CHENNAI METROPOLITAN DEVELOPMENT AUTHORITY
Thalamuthu Natarajan Building, No.1, Gandhi Irwin Road, Egmore,
Chennai - 600 008

Letter No.PP/IND/N/814/2019, Dated: 23.12.2019

Sub: CMDA – Area Plans Unit - ‘B’ Channel (North) - Planning Permission Application is for the proposed construction of Ground Floor + First Floor part Steel Works Building at S.No.139/1 & 139/2 of Thirunilai Village, Ponneri Taluk, Thiruvallur District – Remittance of DC & Other charges – DC advice Sent – Reg.

SITE PLAN

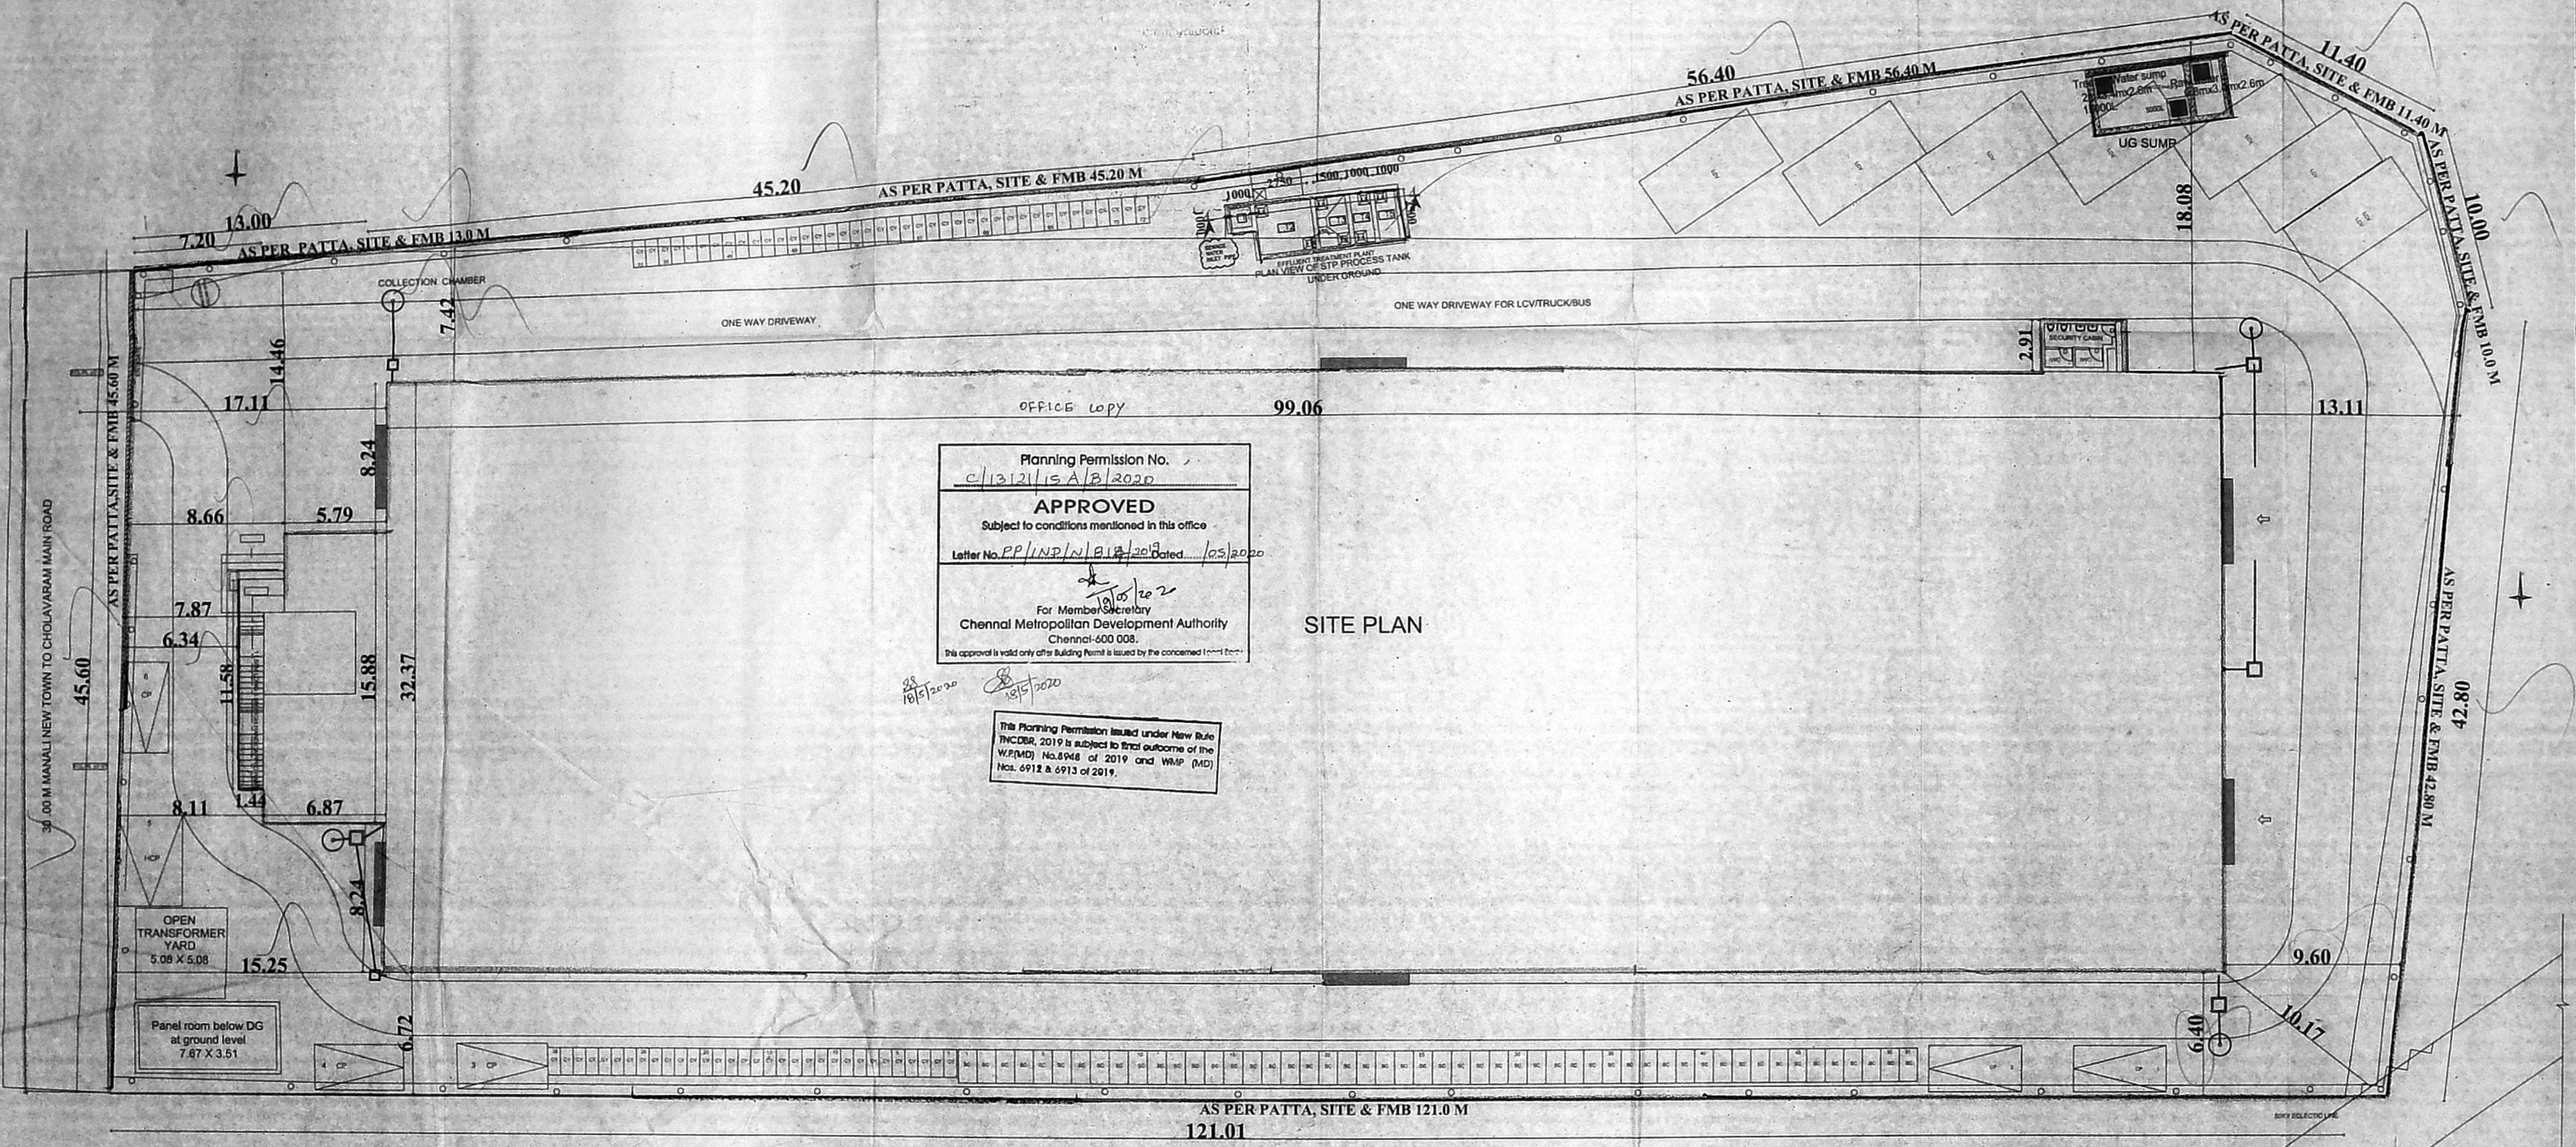
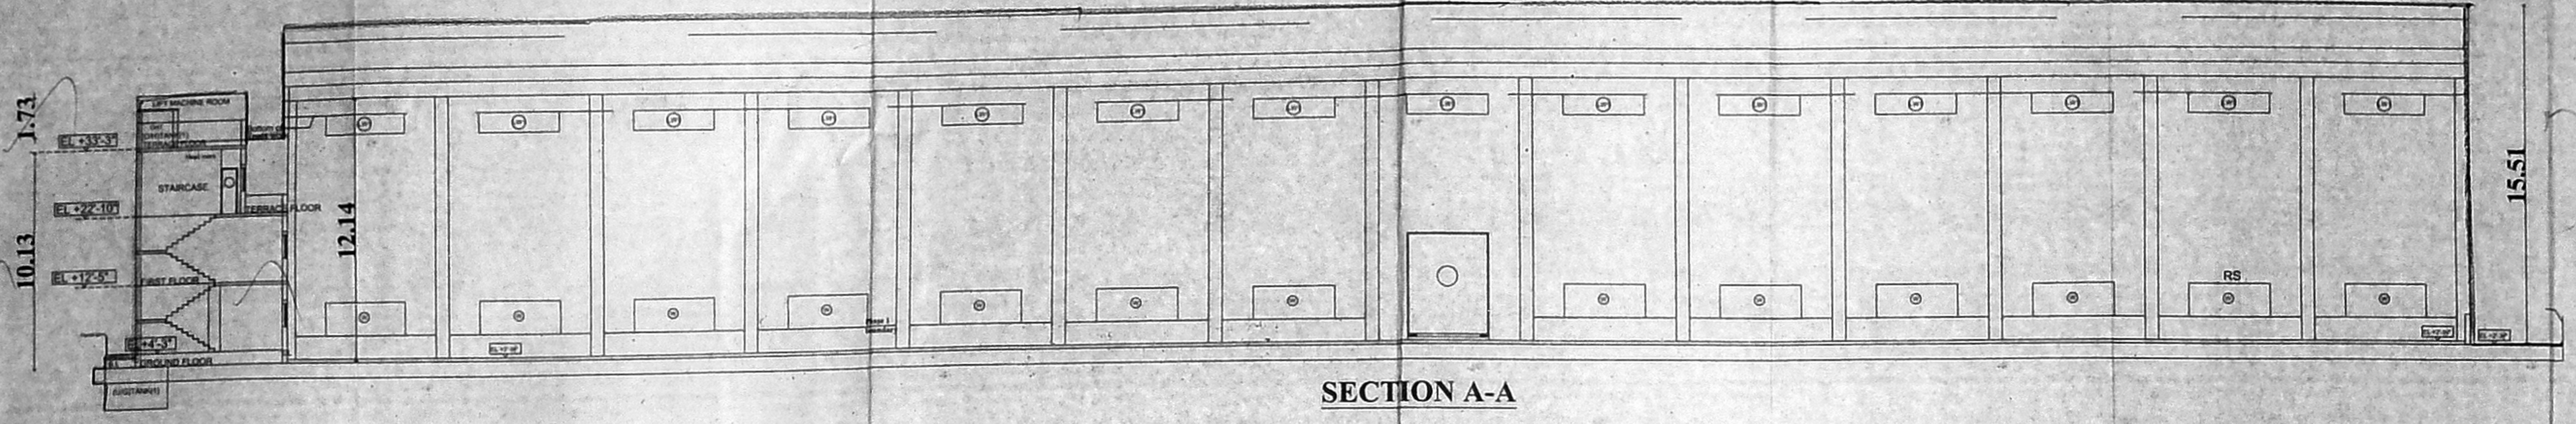
6. You are requested to furnish the following particulars and 5 copies of revised plan rectifying the following corrections:
1. Dimension of the site both as per FMB and site conditions to be shown distinguishing the difference by hatching and showing setback from minimum dimensional line to be furnished.

6. Correct road width to be shown in the site plan as per the Combined FMB sketch.
 7. Area statement and Title needs correction.
 8. Plan to be numbered sequentially.

15. The unwanted text in the site plan to be removed.
16. As extent of site is more than 3000q.m, OSR charges is collectable.
17. Acceptance letter accepting to remit the OSR charges is to be furnished.
18. The detailed floor plan for the structures in the setback along with section and elevation to be furnished.
